**State Significant Development Application SSD 6617: Notice of Exhibition
Remediation of Part of Hickson Road within the EPA Declaration Area,
Barangaroo**

TfNSW provides the following comments on the development application.

Figure 12 Bus services post 4 October 2015

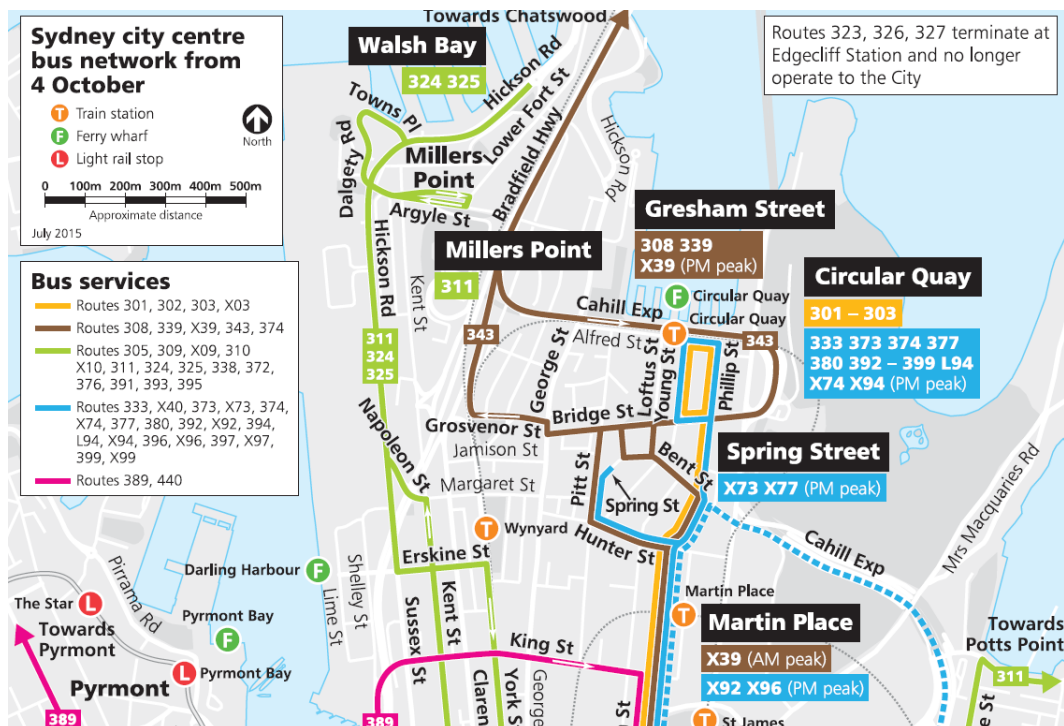
Based on the above, several construction projects are expected to occur at the same time with the proposed temporary road closures/diversions within the Barangaroo and Wynyard Precincts. TfNSW advises that regular bus route services (and associated bus stops) have been in operation since 4 October 2015 and operate along Hickson Road and Napoleon Street as part of the CBD Bus Plan. These include Routes 311, 324 and 325.

The cumulative increase in construction vehicle movements from the construction projects within the Barangaroo and Wynyard Precincts with the proposed temporary road closures/diversions could have the potential to impact on bus movements in the CBD and the safety of pedestrians and cyclists, particularly during the commuter peak periods.

TfNSW requests that the proponent prepares a detailed Construction Pedestrian and Traffic Management Plan (CPTMP) prior to commencement of construction, which takes into account the following

- Other construction projects in the Barangaroo and Wynyard precincts;
- Temporary road closures/diversions in place during remediation works;
- Bus services (and associated bus stops) along Hickson Road and Napoleon Street; and
- Provision of footpath and separated cycleway throughout the construction period with safe crossing points along Hickson Road.

The CPTMP should demonstrate that the construction impacts on the road network, bus operation as well as pedestrian and cyclist safety can be managed. The CPTMP should be prepared in consultation with TfNSW, Roads and Maritime Services and City of Sydney. The final CPTMP should be endorsed by the CBD Coordination Office within TfNSW.
